From: Jeff Tarling
To: Jean Fraser; Lauren Swett
CC: David Margolis-Pineo; Doug Roncarati
Date: 2/19/2014 3:04 PM
Subject: RE: Rockland Ave Outfall

After a closer review of underground utilities, stormwater and sewer mains along with unexcepted street information, the landscape plan is acceptable as shown for the Rockland Avenue / Capasic Pond project. (we don't have the room or easement to plant additional landscape in the area we discussed)

C-201

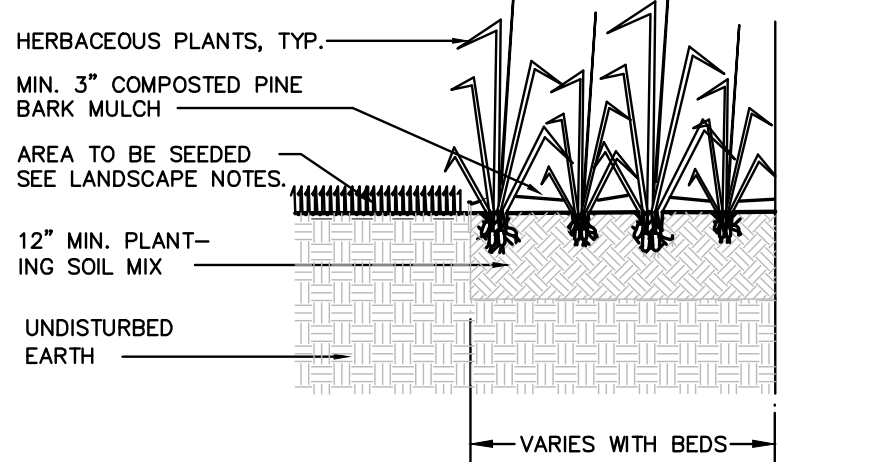
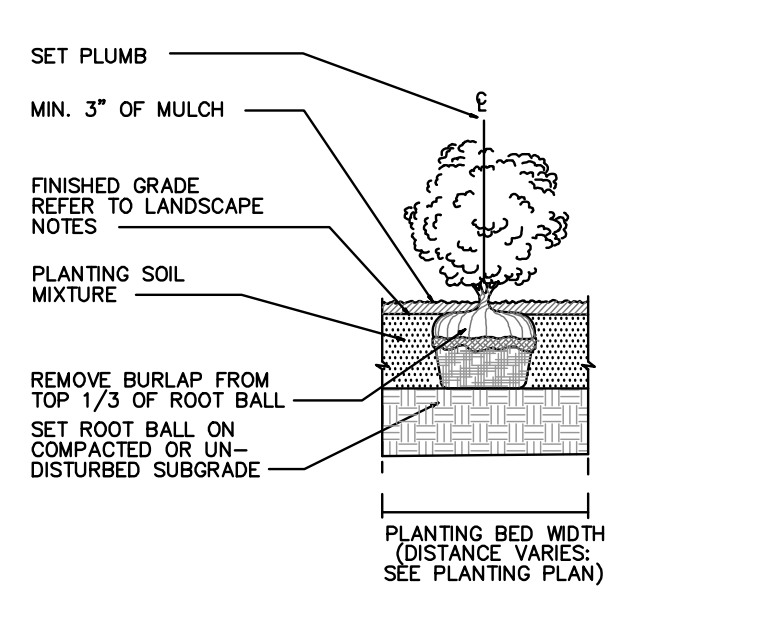
Why isn't there any landscaping shown where the wider paved area is being introduced (where does not exist now) in close proximity to homes and the trail?

Although I am waiting for Jeff to confirm his comments on the proposals, I would like either another site plan or the landscape plan to show just the final condition, with the trail shown and labeled and what is happening (landscape wise) around the new maintenance access and treatment unit (I know its underground but there will be disturbance and round man made features showing above ground I believe.)

ROCKLAND AVENUE OUTFALL
SITE PLAN & PROFILE,
SECTIONS

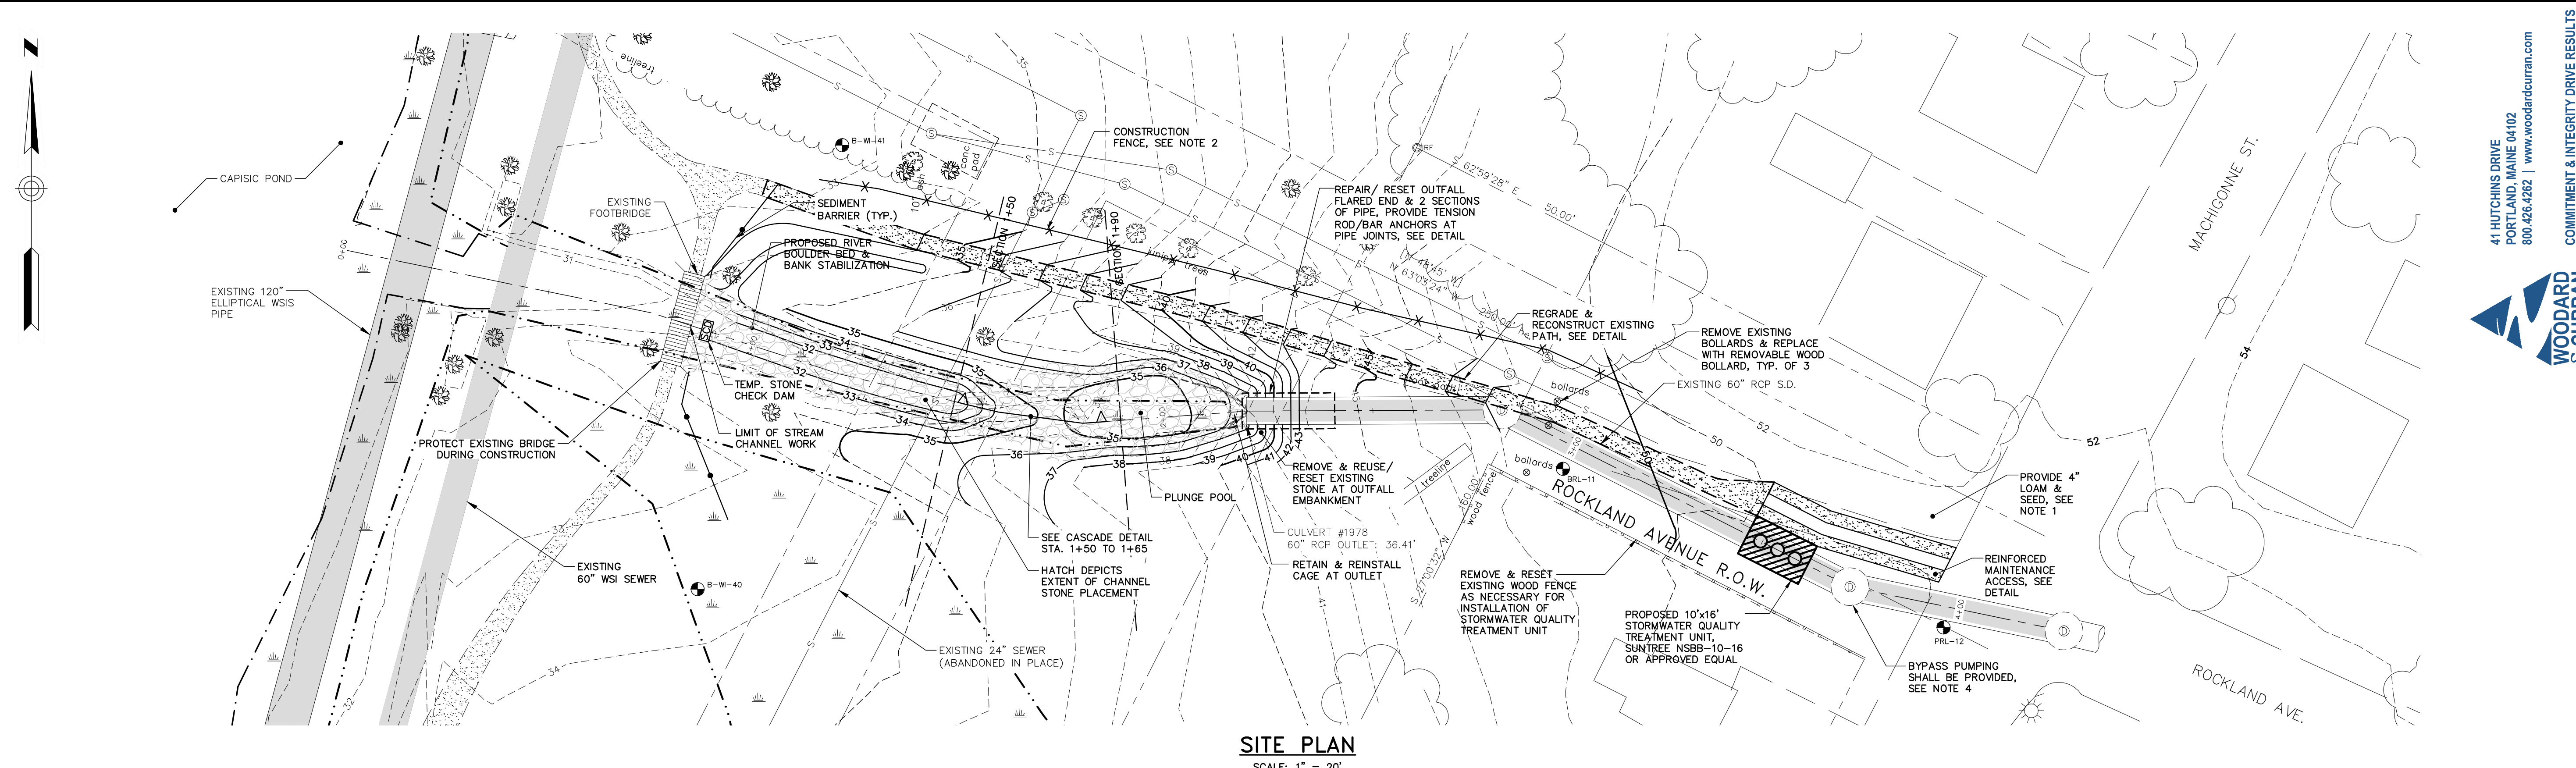
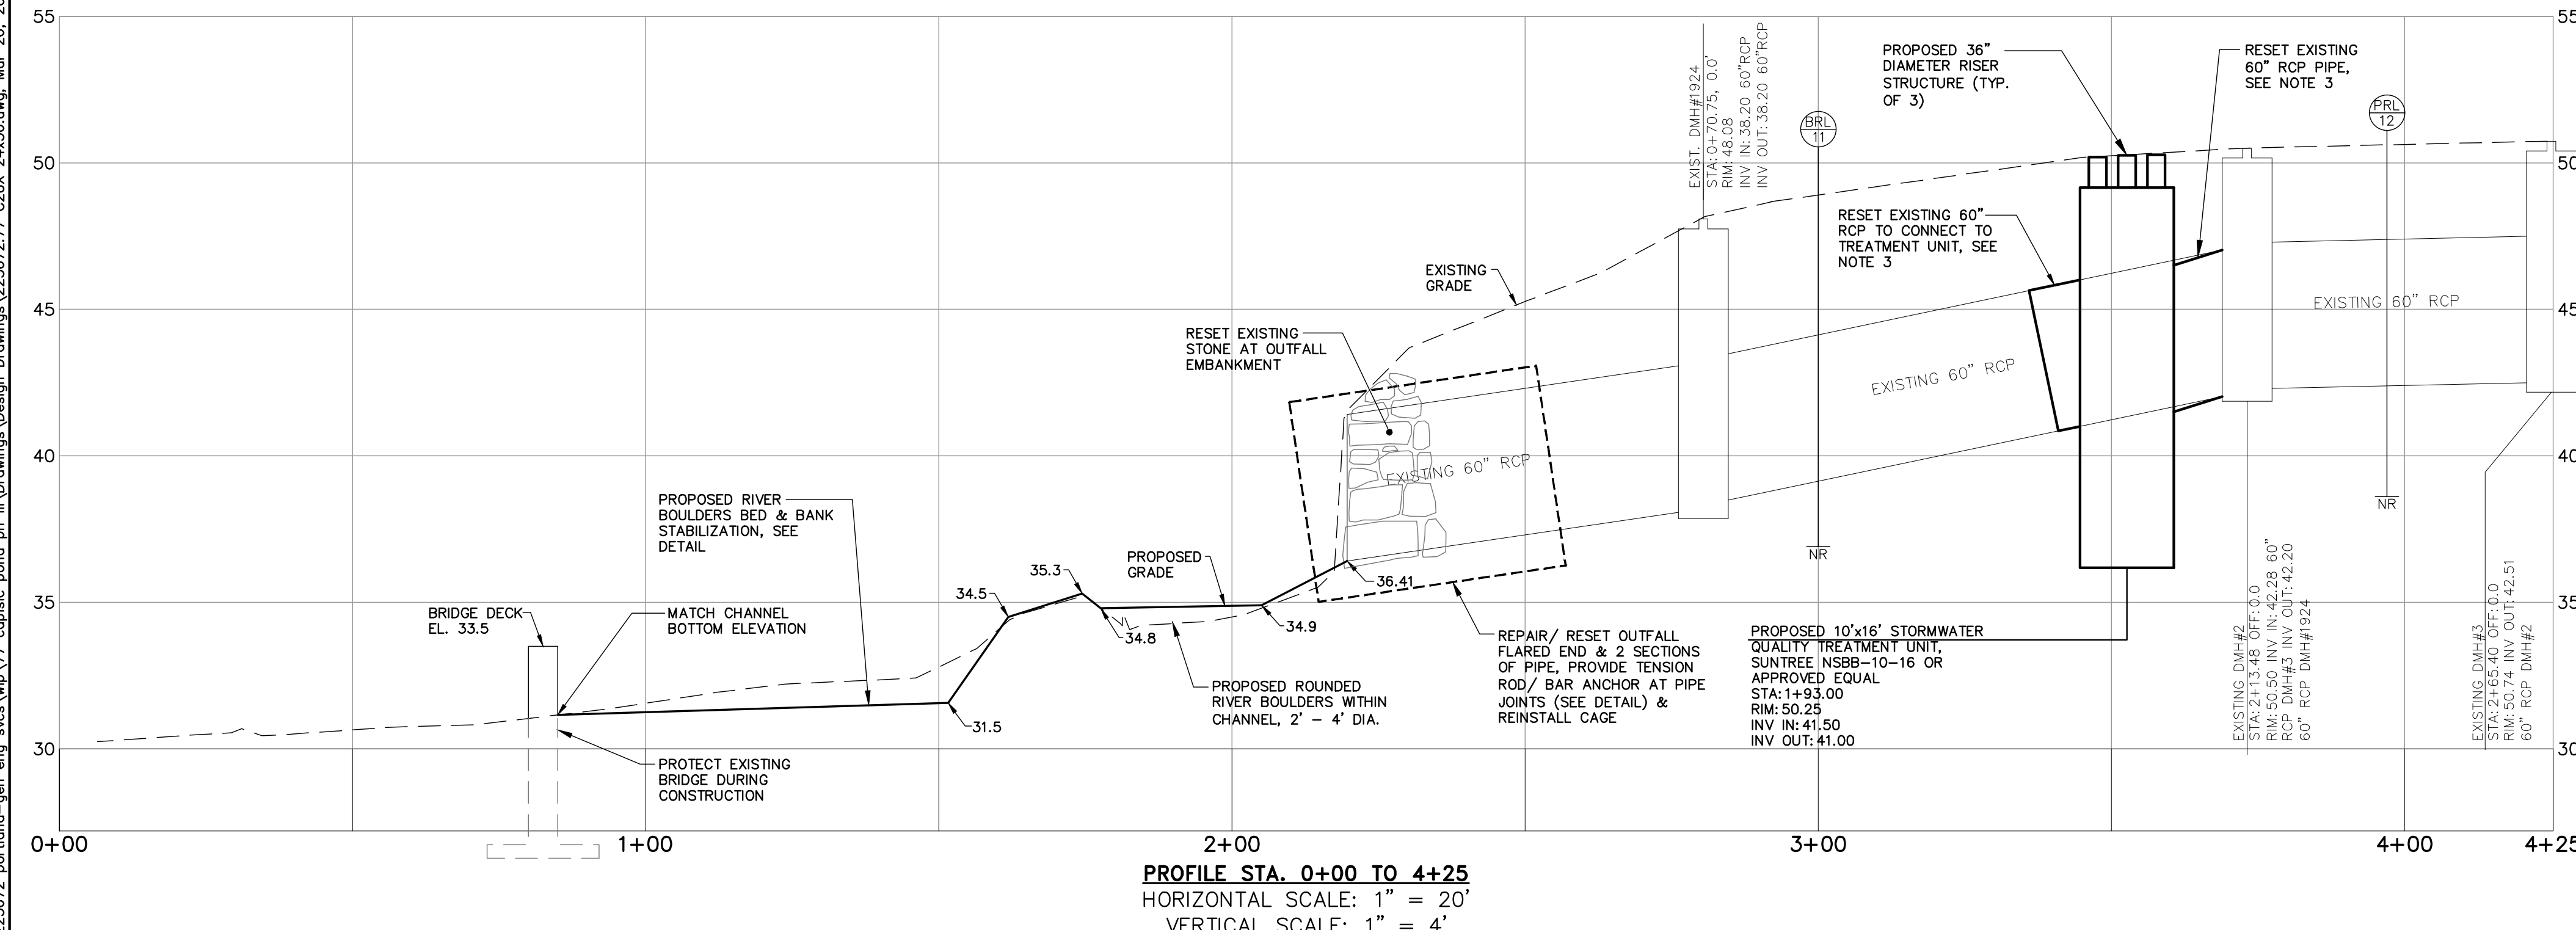
The site plan is confusing as it shows existing, interim (temporary) and final all on one plan- so raises questions:

Presumably the reinforced maintenance access is permanent, so where will the trail be after its temporary location during construcion?
